## 71 Caddie Lane plans review

Pursuant to your email of October 5 and our phone conversation of October 6 and to reflect additional information that has come to light, we have made changes to the drawings as outlined below. We are including drawings that have not been revised so that you can have a complete set, hopefully not jumbled in the City system as was the case when we spoke.

**1 PARTITION TYPE P1**

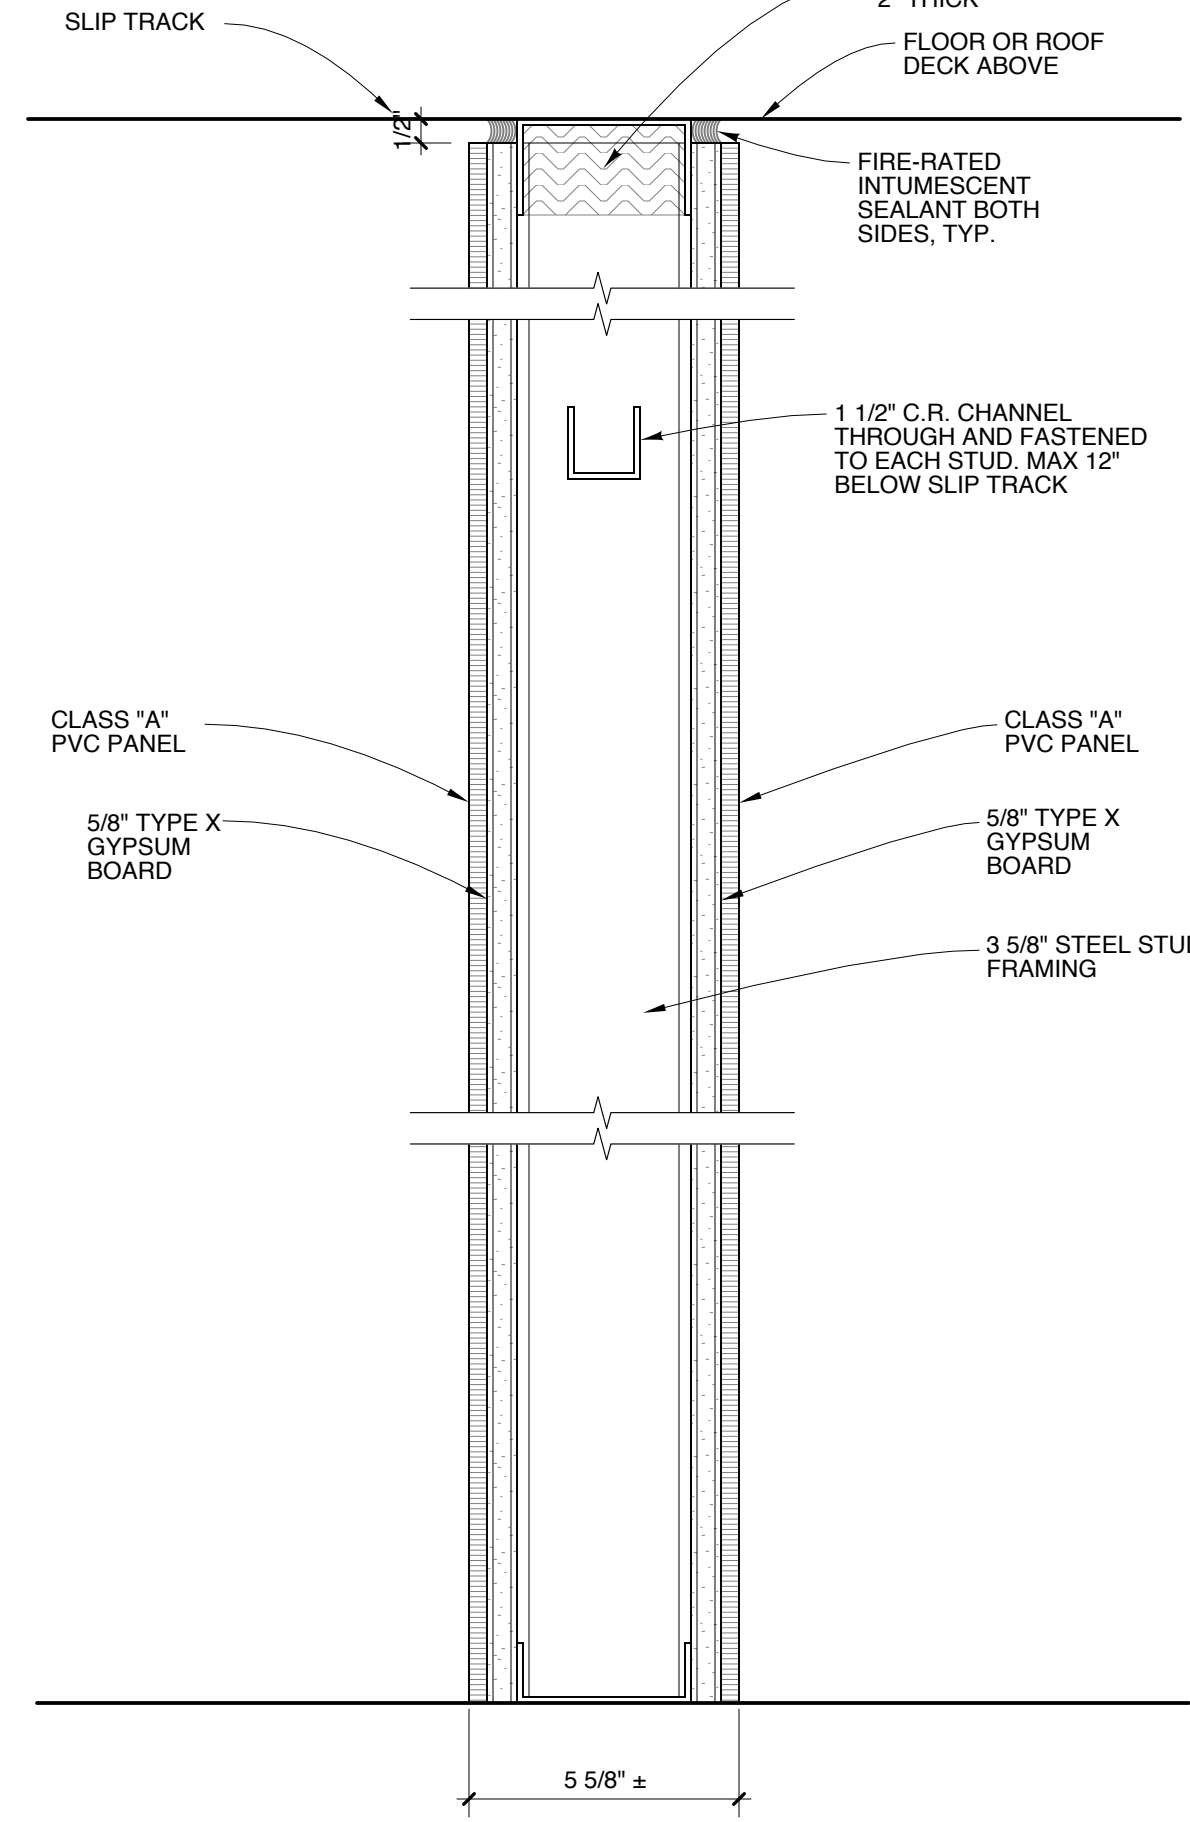
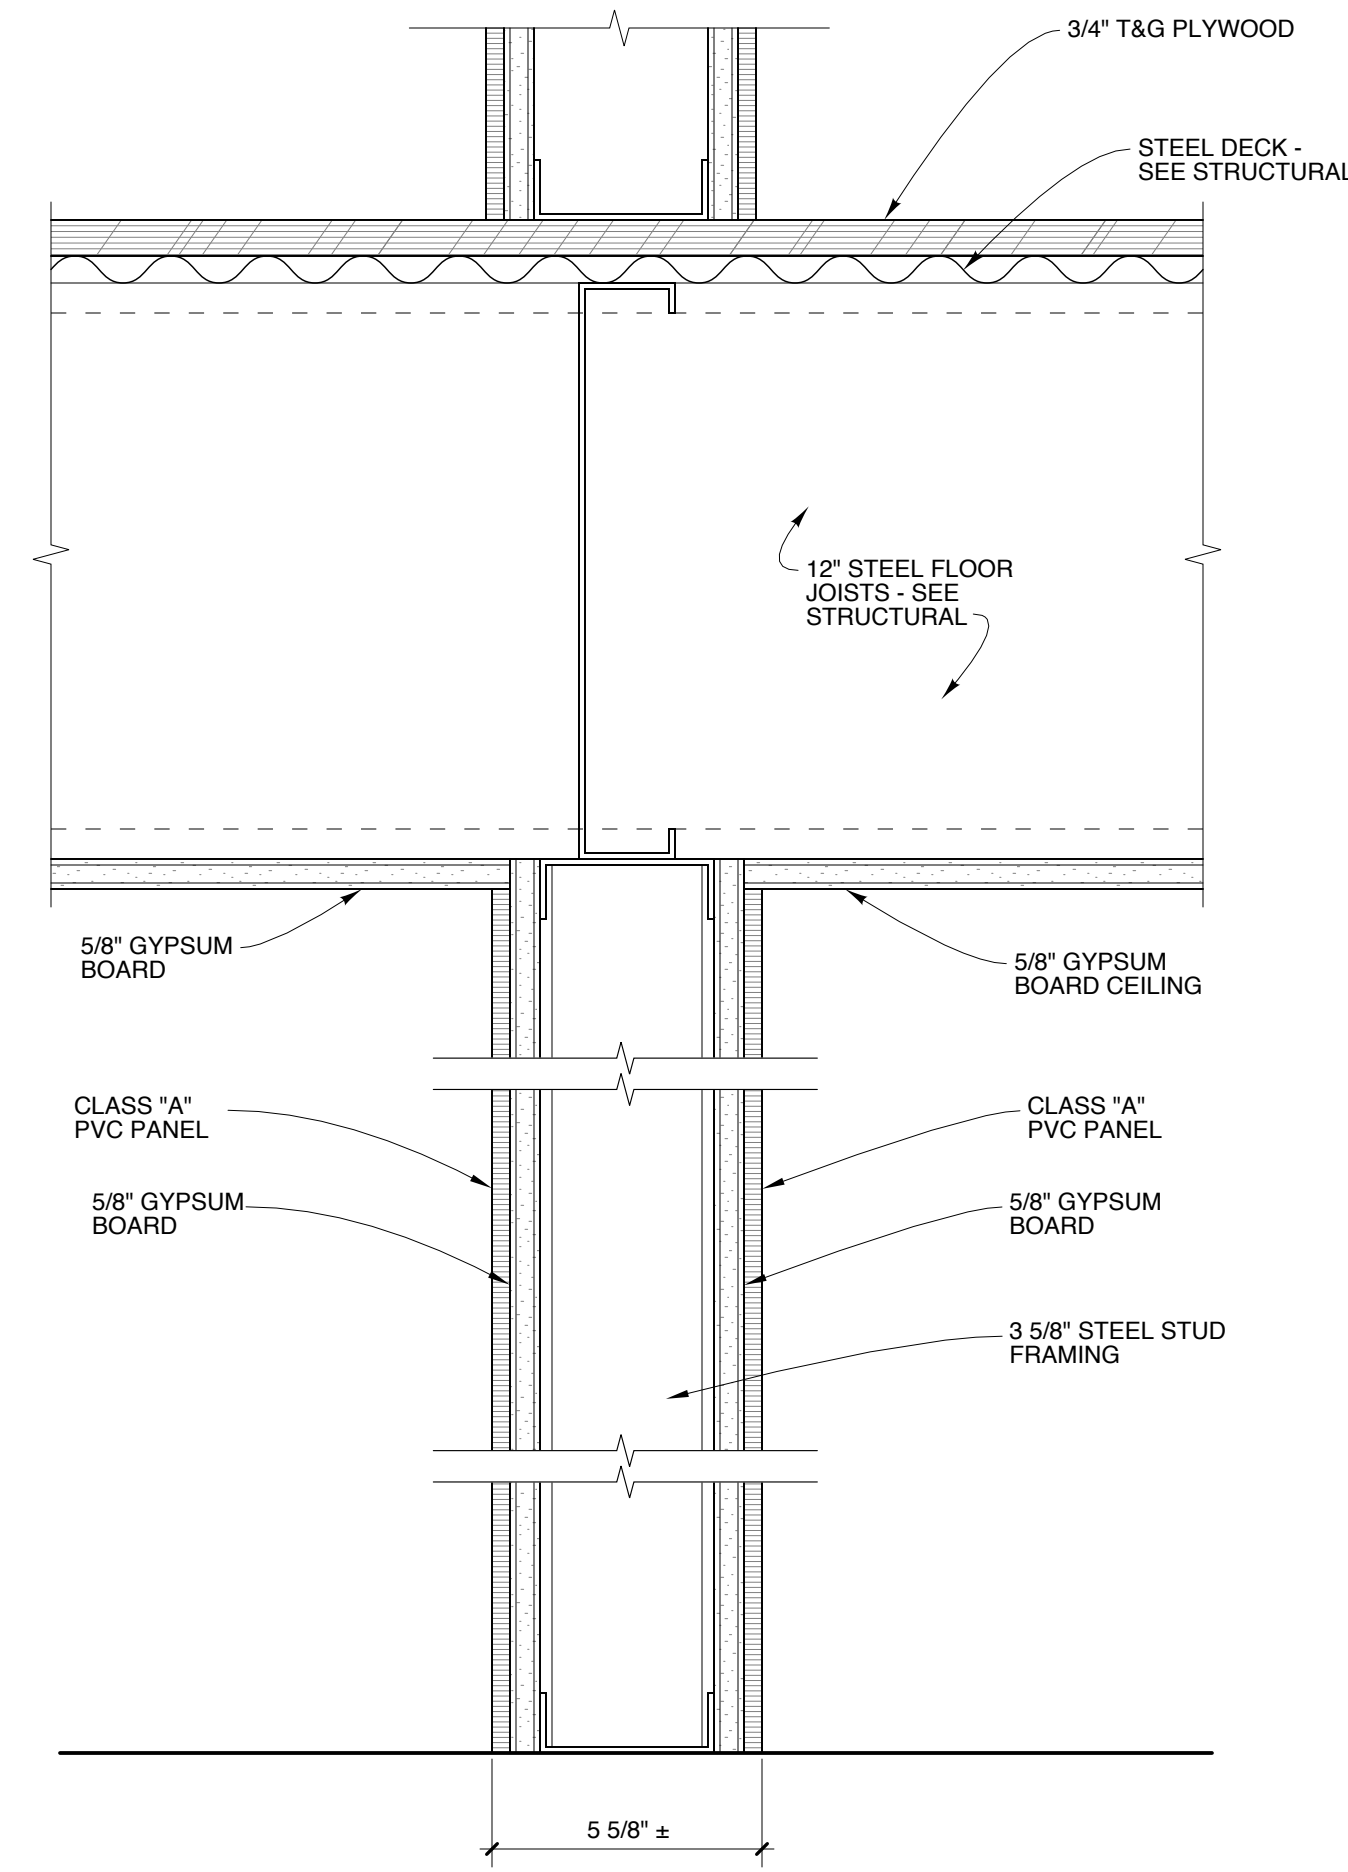
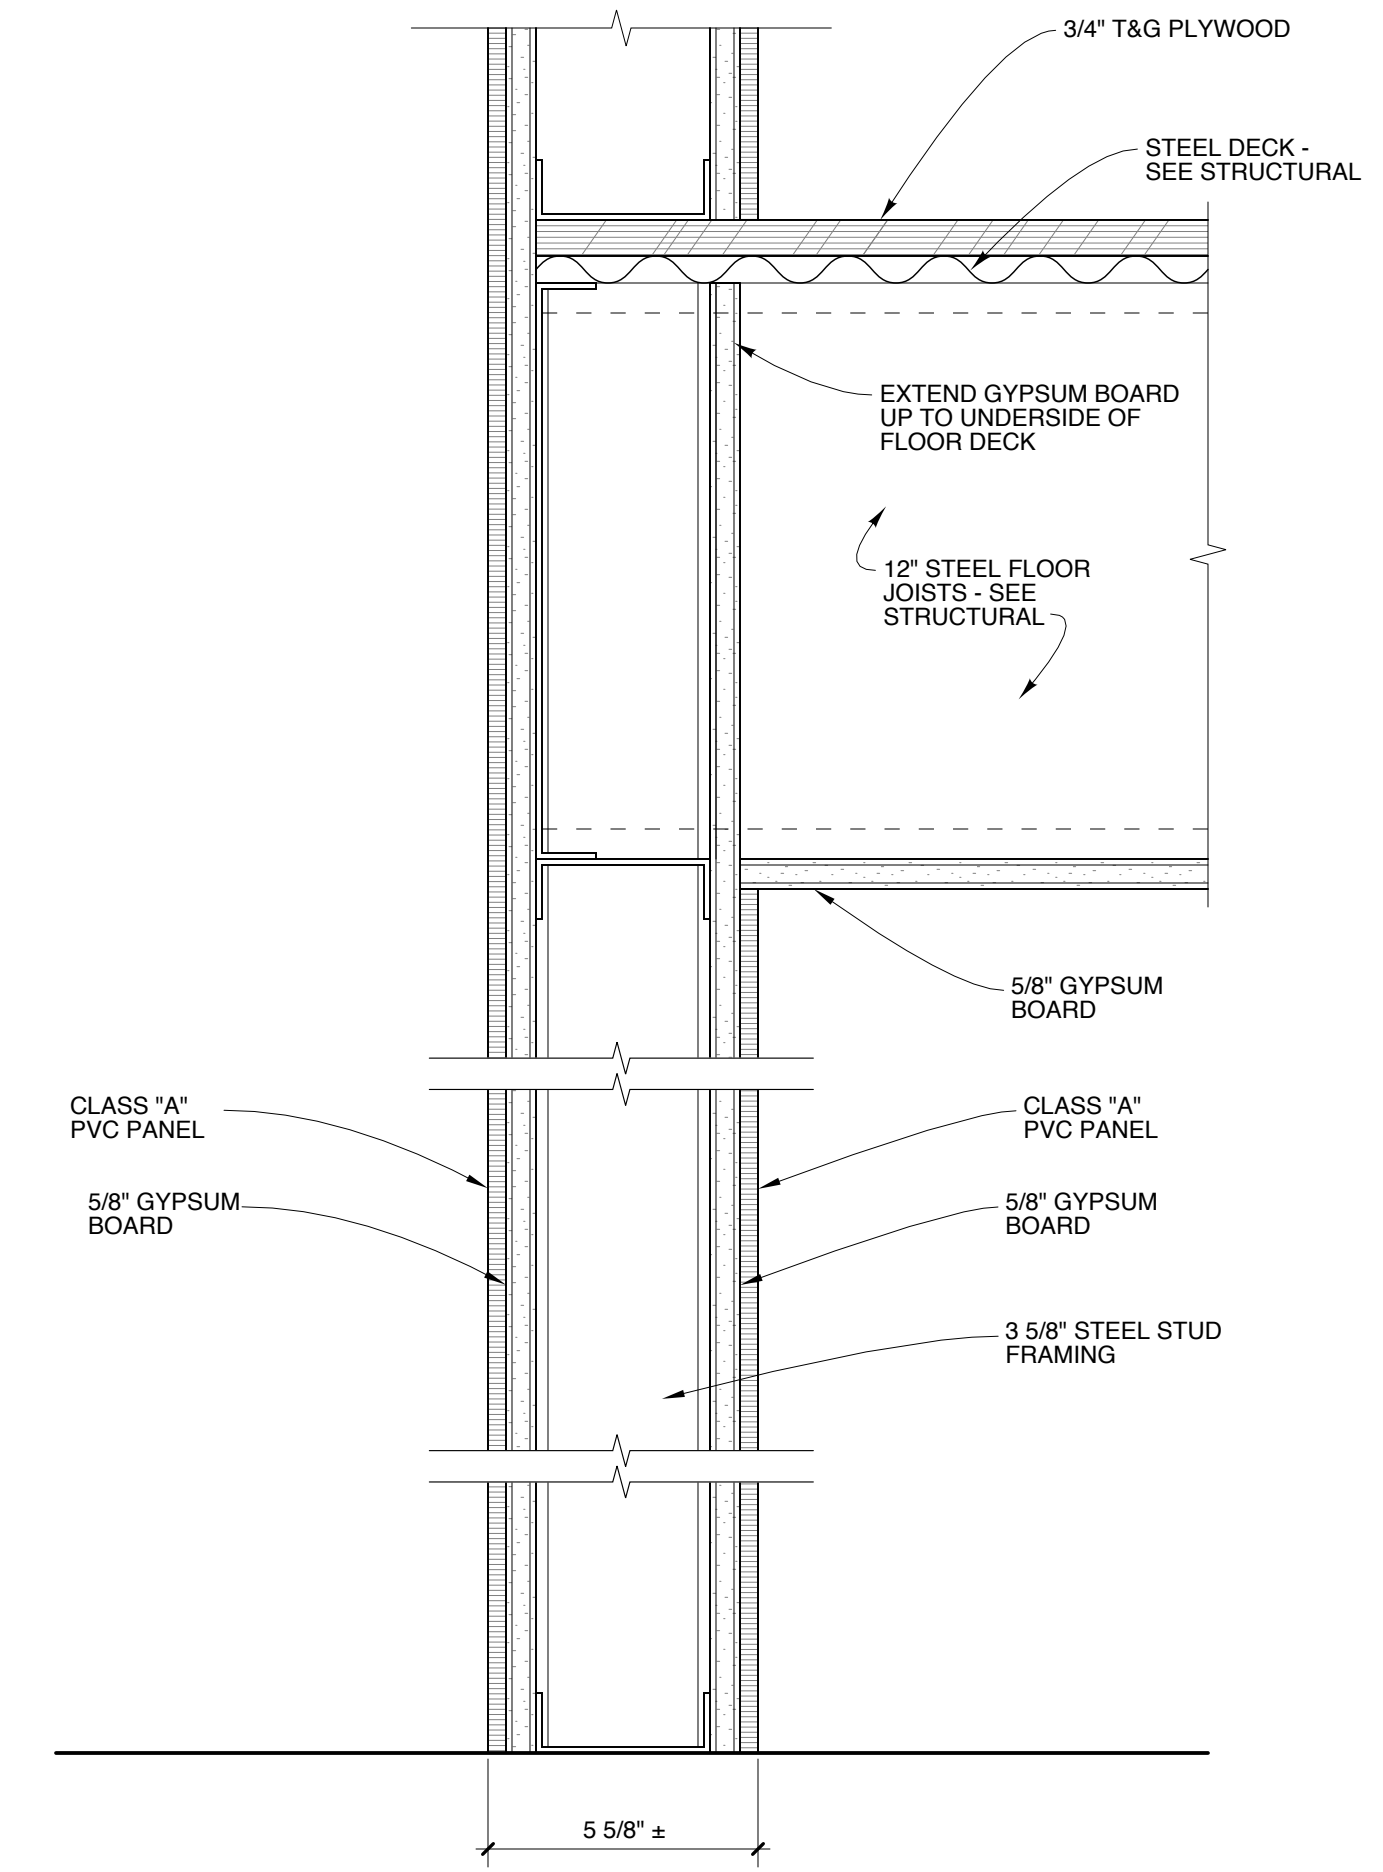
- Your question 1 on the second floor plan was already partially addressed in the shell permit. Details have been added to the partition types that show the exterior wall finish detail: 1 1/2" deep hat channels run vertically at 24 inch horizontal spacing with Class "A" PVC panels running horizontally floor to ceiling. Class "A" PVC panels have been added to other partition details.

- Partition types have been revised to show Class "A" PVC panels in various locations.
- Fire rated bearing walls are now detailed to show gypsum board extending to the underside of the floor deck above on both sides of the wall.
- Drawing is dated 10/18/17.
